From: Thomas Callaway
Sent: 30 July 2015 14:48
To: Planning.Responses
Subject: RE: Planning Consultation on: Y/50/15/HH

APPLICATION Y/50/15/HH

Site Address: Meadow Cottage Hoe Lane Flansham PO22 8NT

Description of Works: Two storey side extension to existing cottage

Drawing
Roof Plan

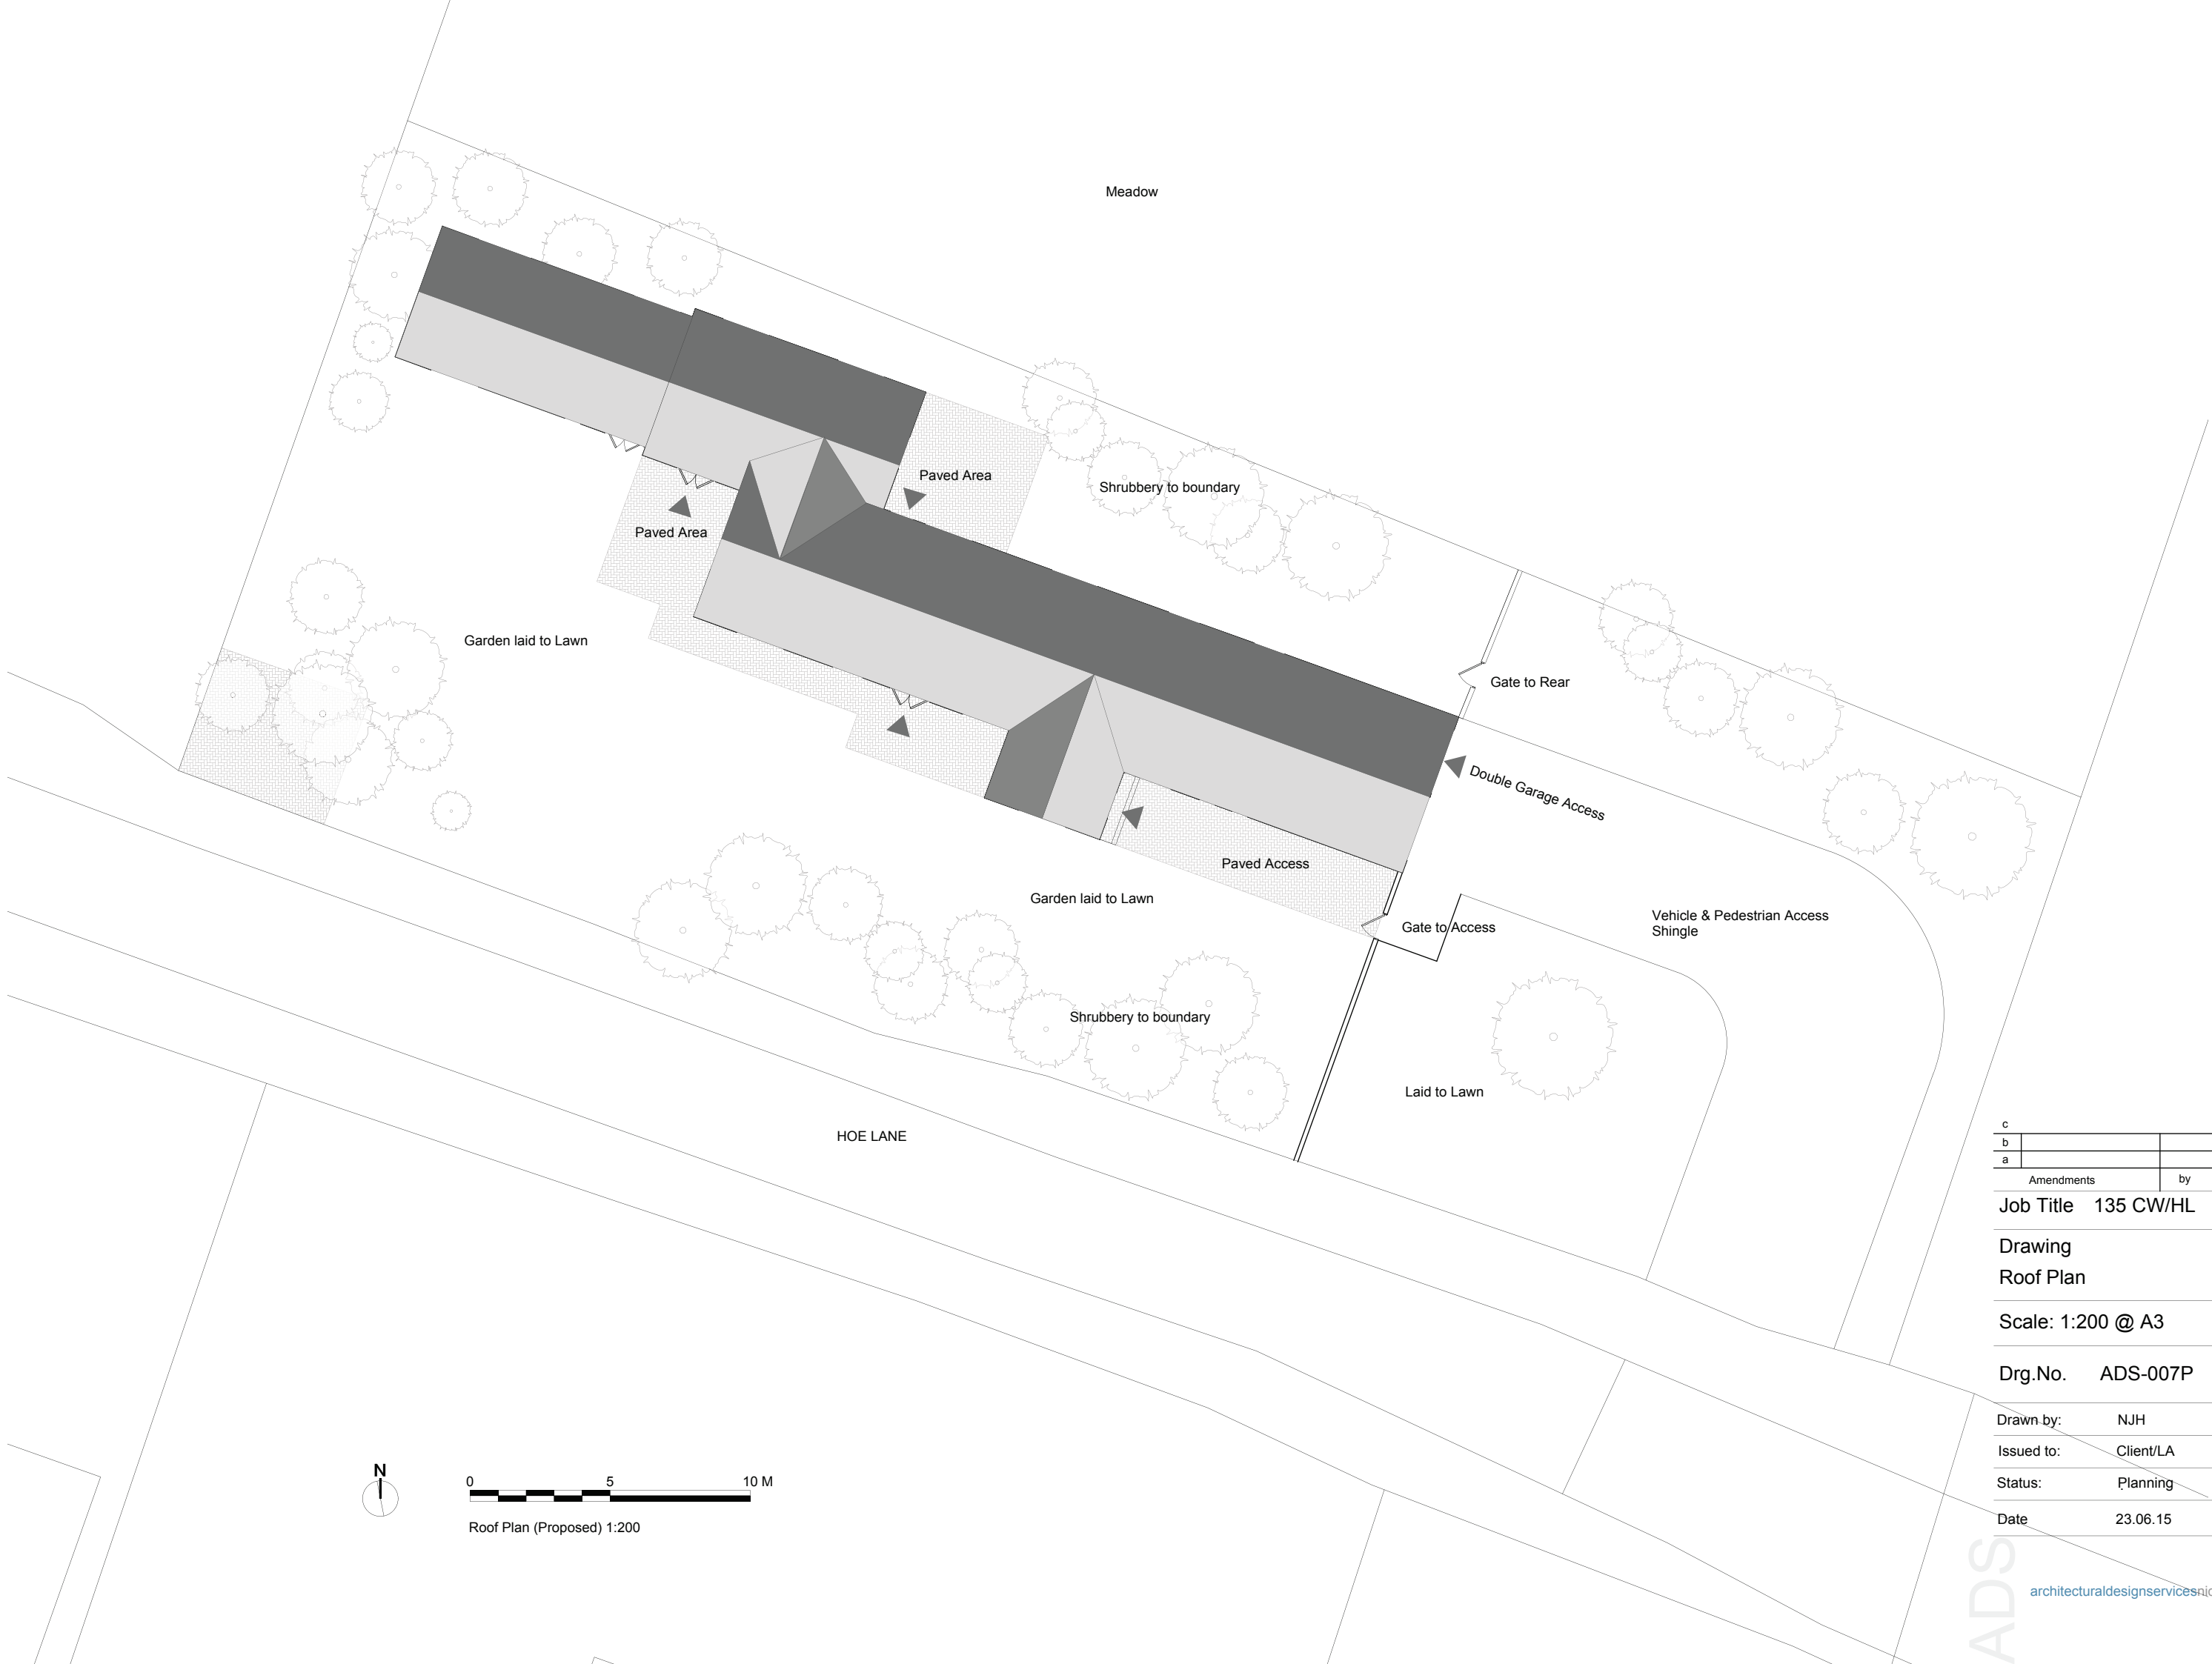
Infiltration should be investigated for surface water drainage for new roof areas.

Please apply standard conditions ENGD2A.

Infiltration rates for soakage structures are to be based on percolation tests undertaken in the winter period and at the location and depth of the proposed structures. The percolation tests must be carried out in accordance with BRE 365, CIRIA R156 or a similar approved method and cater for the 1 in 10 year storm between the invert of the entry pipe to the soakaway, and the base of the structure. It must also have provision to ensure that there is capacity in the system to contain below ground level the 1 in 100 year event plus 30% on stored volumes, as an allowance for climate change. Adequate freeboard must be provided between the base of the soakaway structure and the highest recorded annual groundwater level identified in that location.

Any SuDS or soakaway design must include adequate groundwater monitoring data to determine the highest winter groundwater table in support of the design. The applicant is advised to discuss the extent of groundwater monitoring with the Council's Engineers. Supplementary guidance notes are also enclosed for information.
